Addendum #1

**Peoples Regional Opportunity Program
Phase III Scattered Site Affordable Housing
Anderson & Cumberland Streets, Portland, Maine 04101
North Street, Westbrook, Maine 04101**

January 28, 2005

TFH Architects
100 Commercial St.
Portland, Maine 04101

9 BRICK WITH BITUMINOUS BASE SIDEWALK AND DRIVEWAY CONSTRUCTION NOT TO SCALE

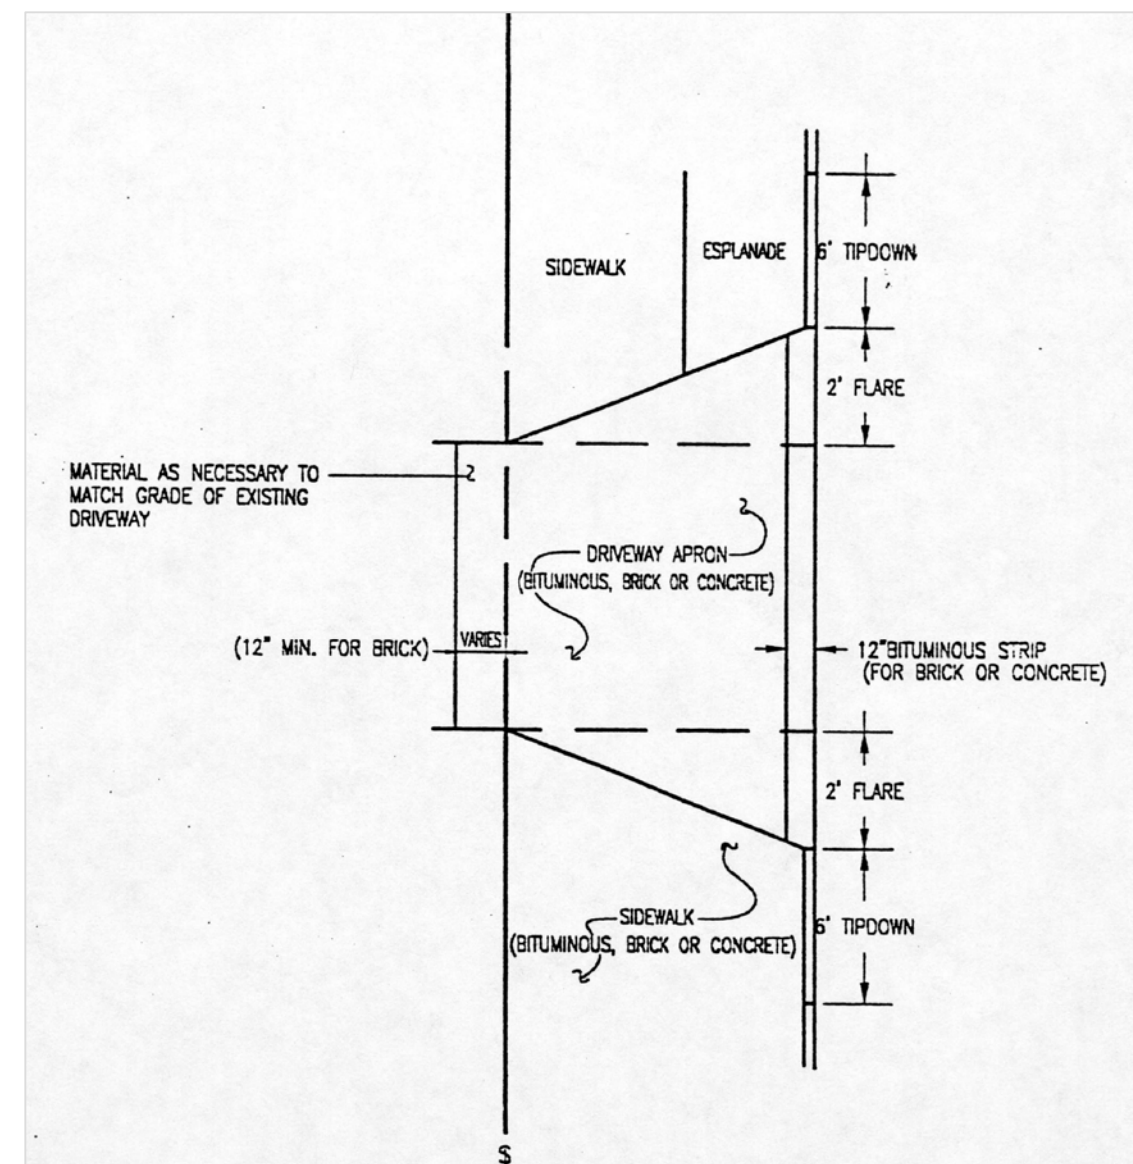
- 1-13 C1 Cumberland Replace the entire sidewalk towards Cumberland Avenue with brick sidewalk. The entire sidewalk will be disturbed when the shoring system is installed. Finish per City Standards.
- 1-14 C1 Cumberland Delete 4 floor drains and connection to storm drain system.
- 1-15 C1.0 23 North Add 8' of 8" pipe, stub and cap for future use. See SkC-4.
- 1-16 A4.0 Anderson 3,4 Add geotech fabric per Geotech reports
- 1-17 A4.0 15, 17 North St. 3,4 Add geotech fabric per Geotech reports
- 1-18 A1.0, A1.1, A1.2, All sites Add note 11 for underlay @ linoleum floors.
